Traffic Impact Study

# Monument Hill

El Paso County, Colorado

September 14, 2022  
\_\_\_\_\_  
Date

**Author:** CDurham

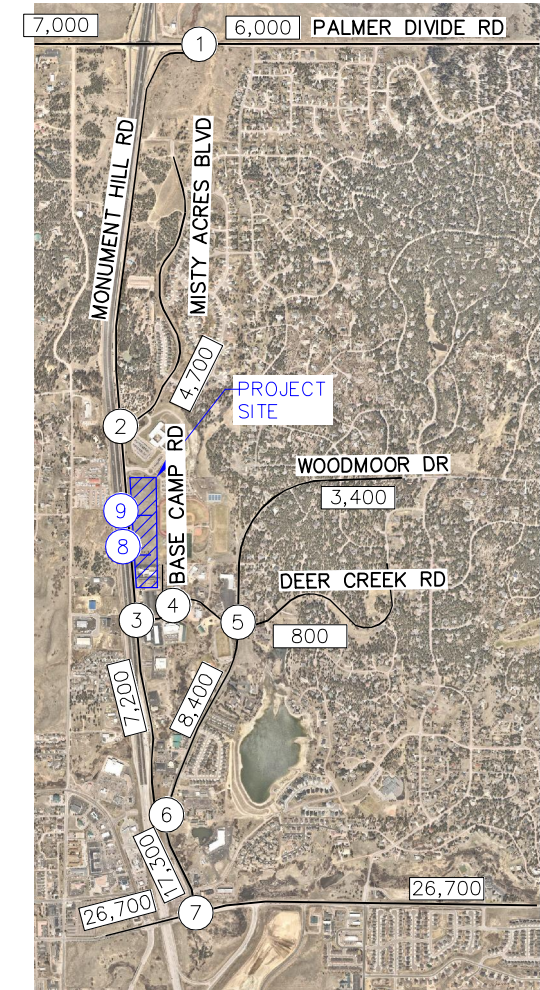
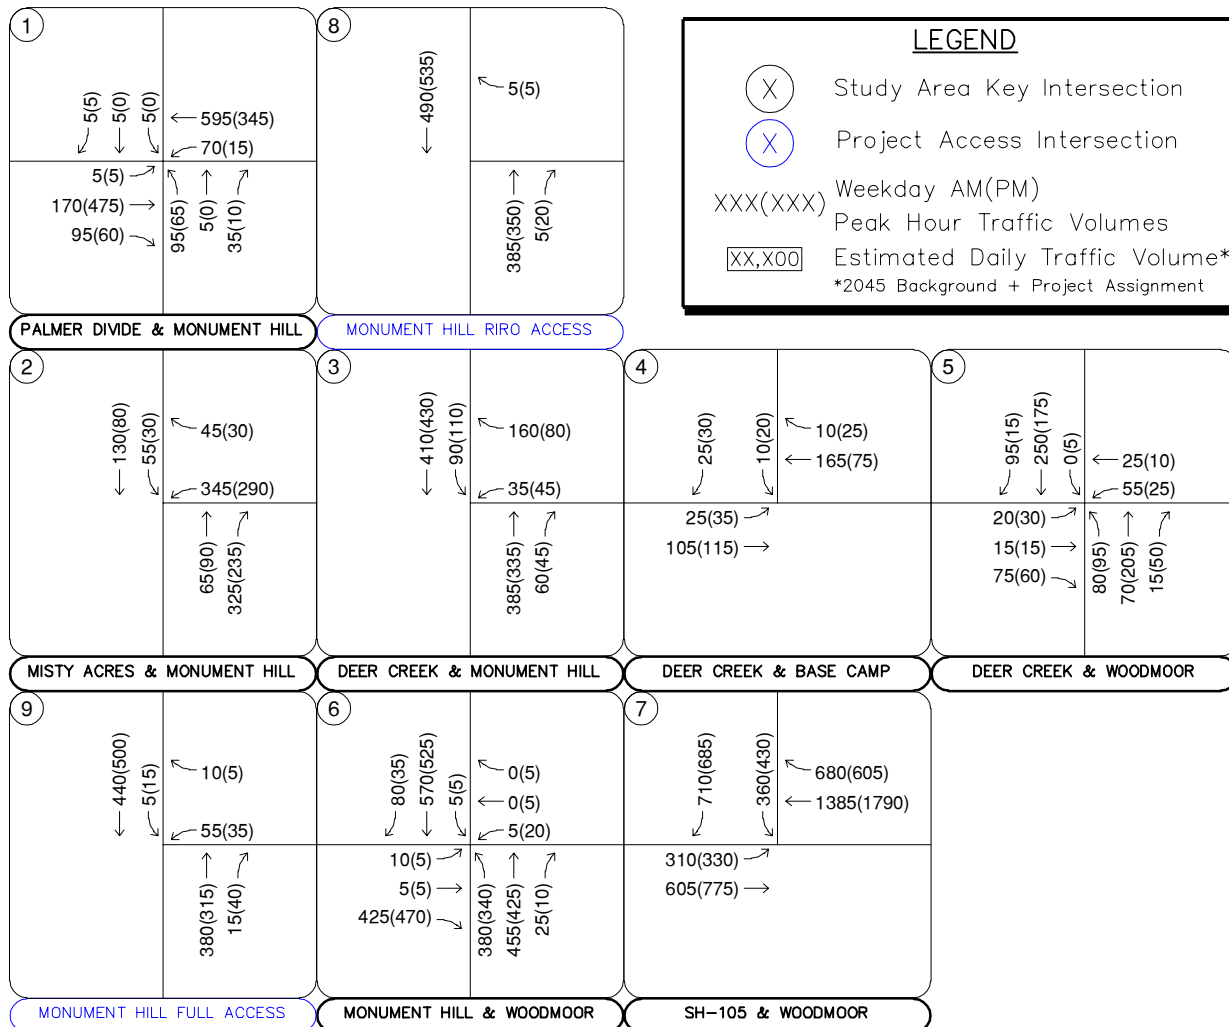
Provide more description on how thru volumes at intersections 8 & 9 were determined on this figure.

Provide more description on how these volumes were all determined.

Additional description was provided to explain how the volumes were determined, including a description of how the through volumes at #8 and #9 were determined.
